# CITY OF ALBUQUERQUE

Re: **COA-Westside Vehicle Maintenance/Office Bldg**  
**18000 Cerro Colorado Road SW**  
**Traffic Circulation Layout**  
Architect's Stamp 10-30-2020 (P01-D001A)

Based upon the information provided in your submittal received 10-30-2020, the above referenced plan cannot be approved for Building Permit until the following comments are addressed:

SHEET TITLE:
SITE SIGNAGE

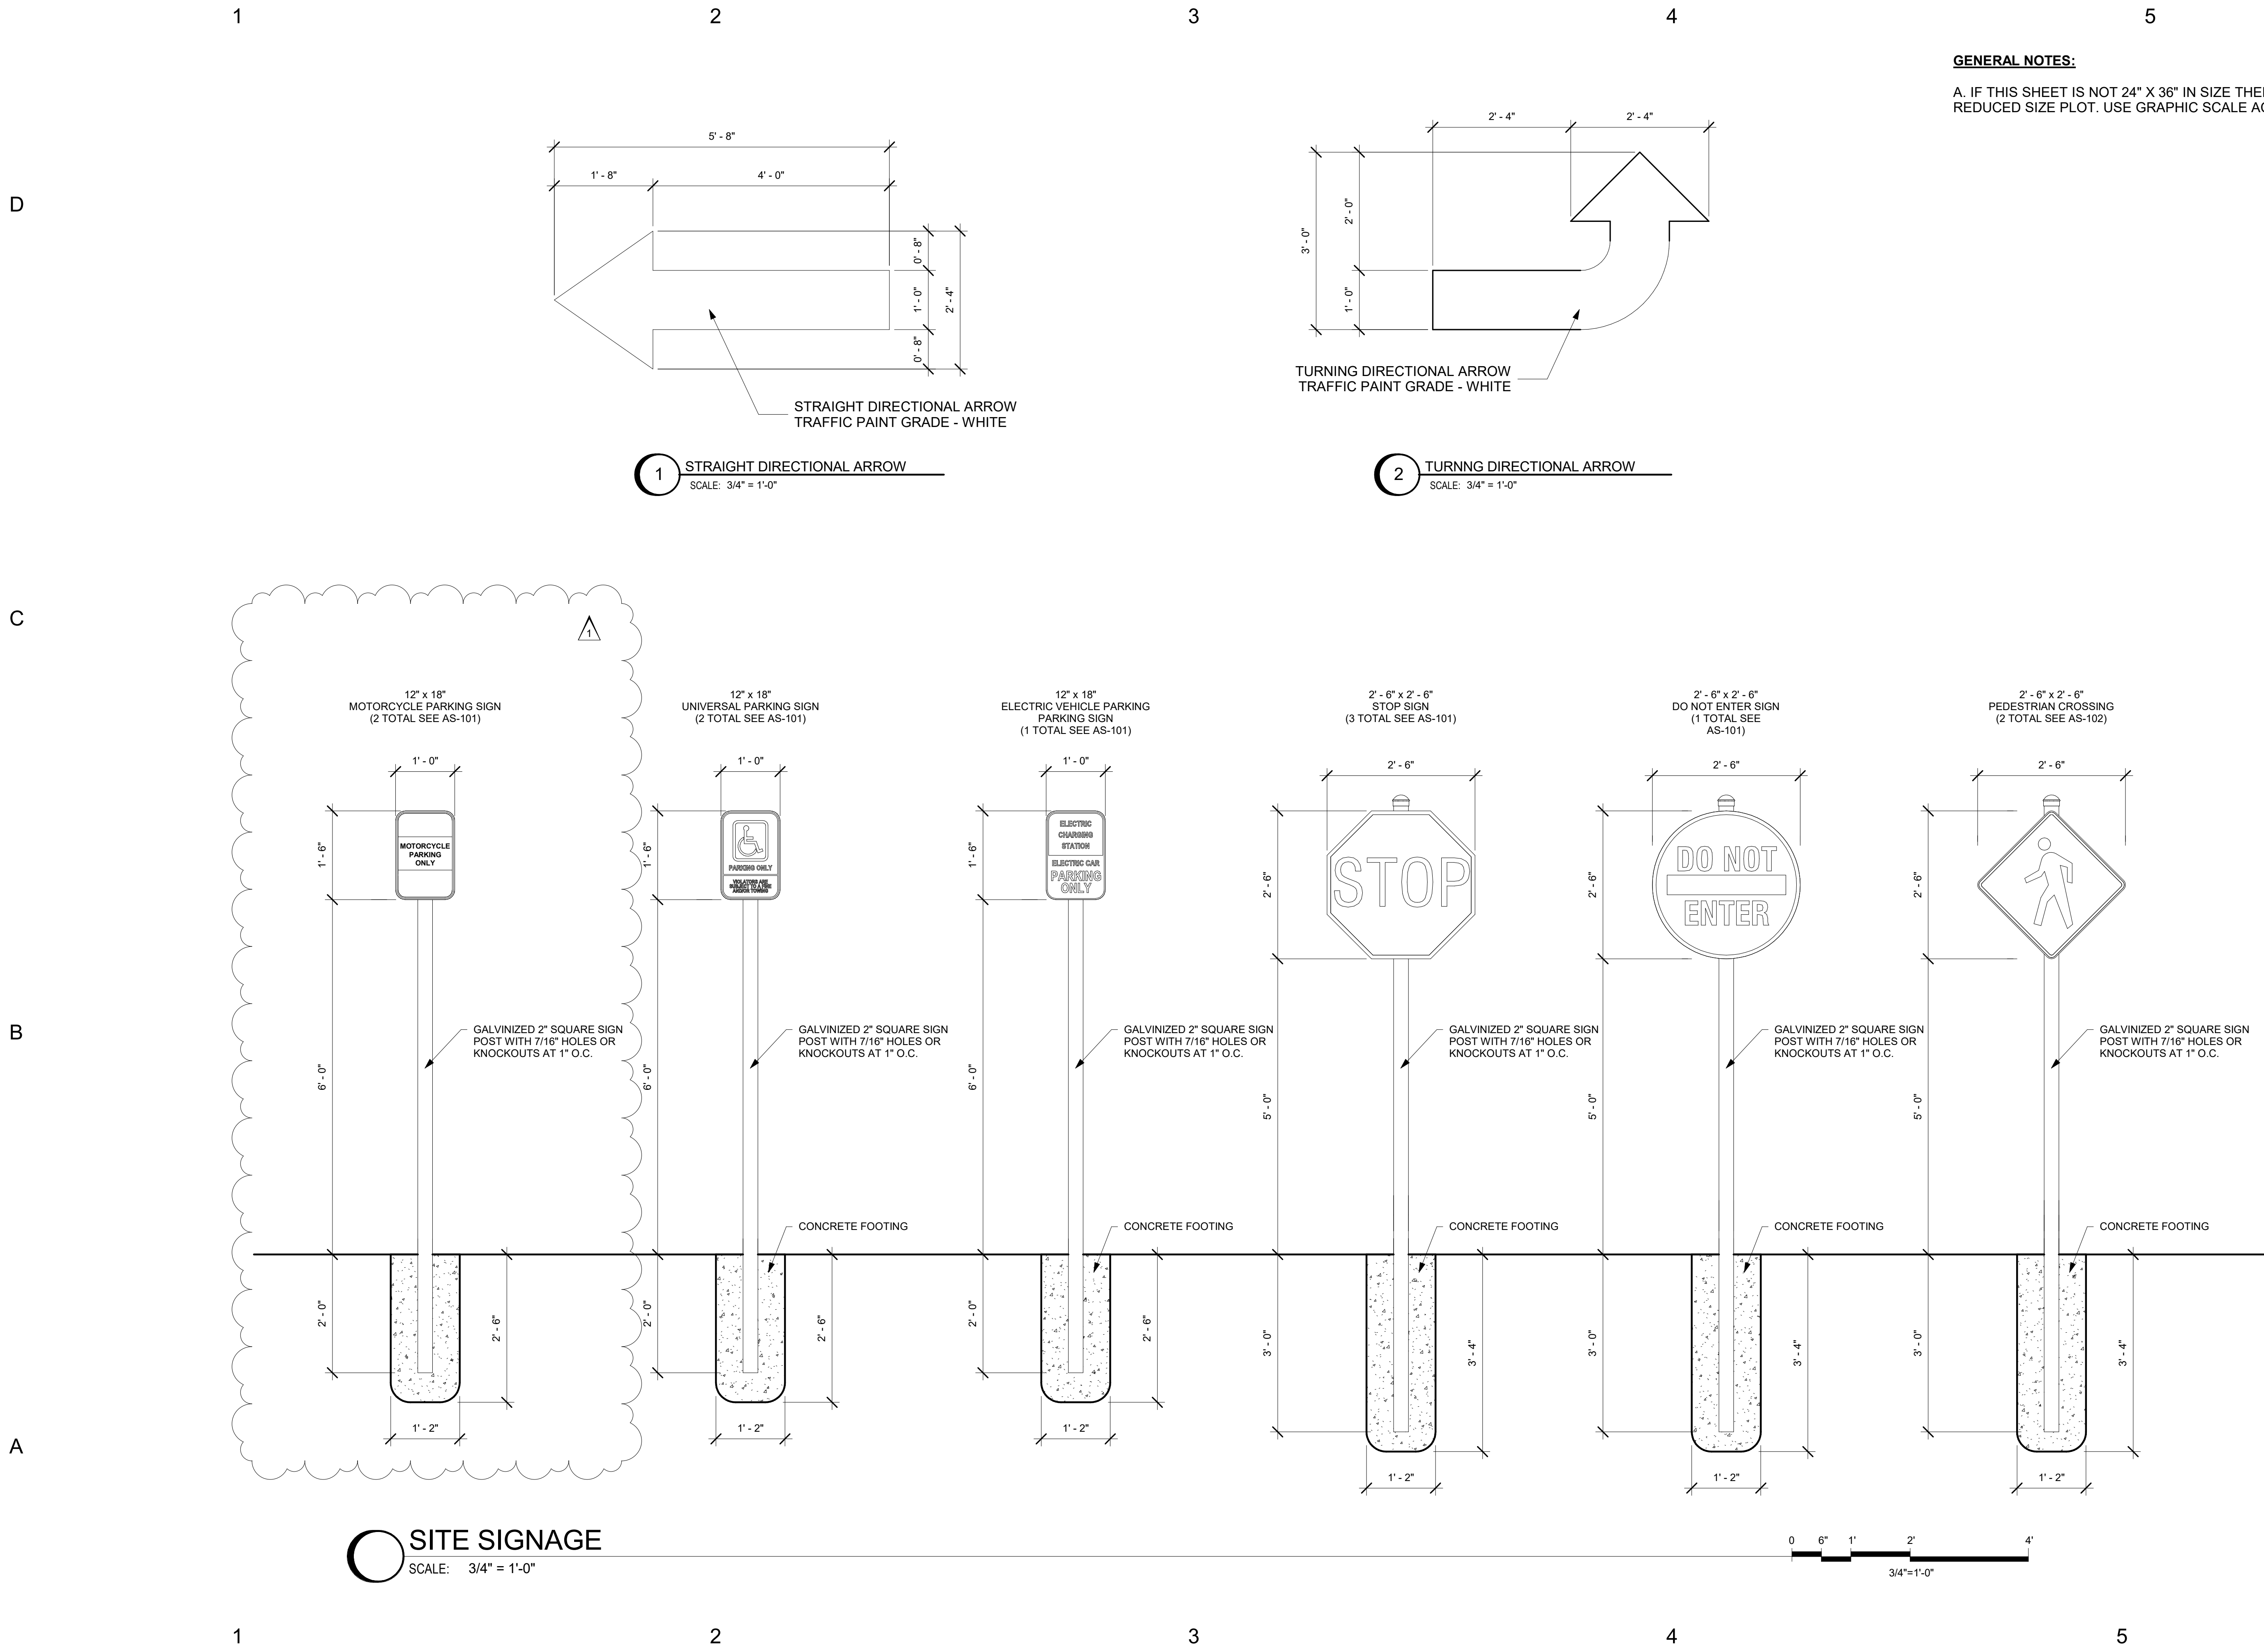
The ADA accessible parking sign must have the required language per 66-7-352.4C NMSA 1978 "**Violators Are Subject to a Fine and/or Towing.**" Please call out detail and location of signs.

The ADA access aisles shall have the words "**NO PARKING**" in capital letters, each of which shall be at least one foot high and at least two inches wide, placed at the rear of the parking space so as to be close to where an adjacent vehicle's rear tire would be placed. (66-1-4.1.B NMSA 1978)

Motorcycle parking spaces shall be designated by its own conspicuously posted upright sign, either free-standing or wall mounted per the zoning code. Label pavement MC.

ADD SIGNAGE 10.

ADD SIGNAGE 11.

ADD SIGNAGE 12.
